REQUEST

Current Zoning: UMUD(O) (Uptown Mixed-Use District, optional).
Proposed Zoning: UMUD(O) SPA (Uptown Mixed-Use District, optional, site plan amendment).

SUMMARY OF PETITION

The petition proposes a site plan amendment to petition 2010-065 to eliminate off-street parking requirements. The site is currently developed with a hotel.

Planning Department

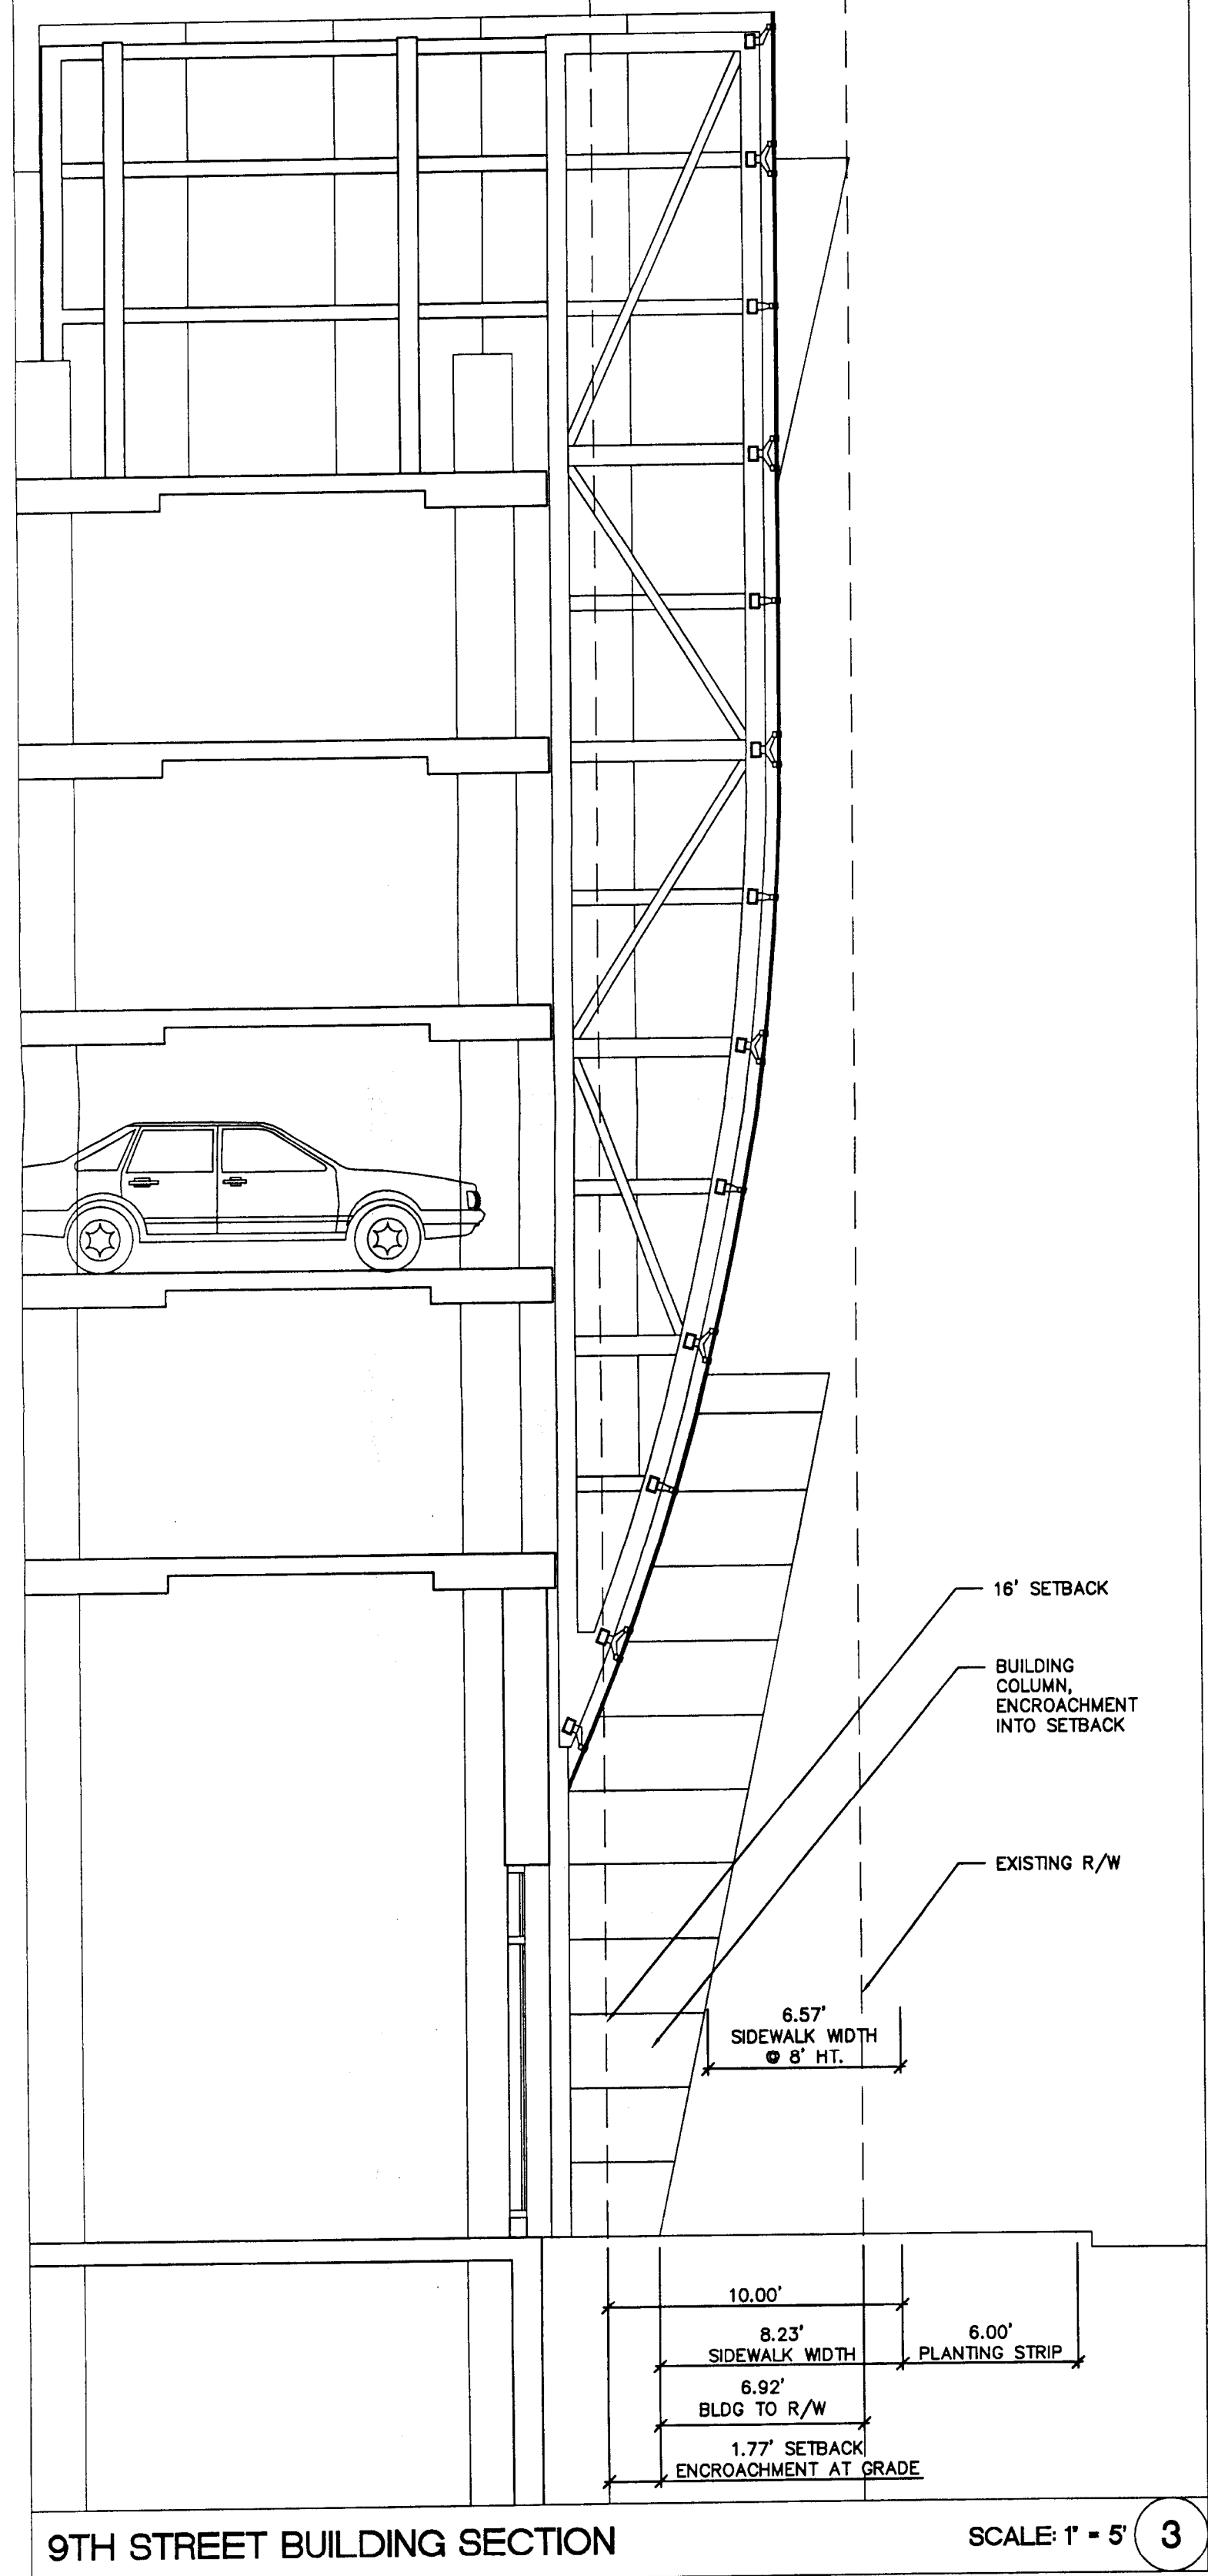
1. Entitlement Services: Add rezoning petition number to site plan.
-
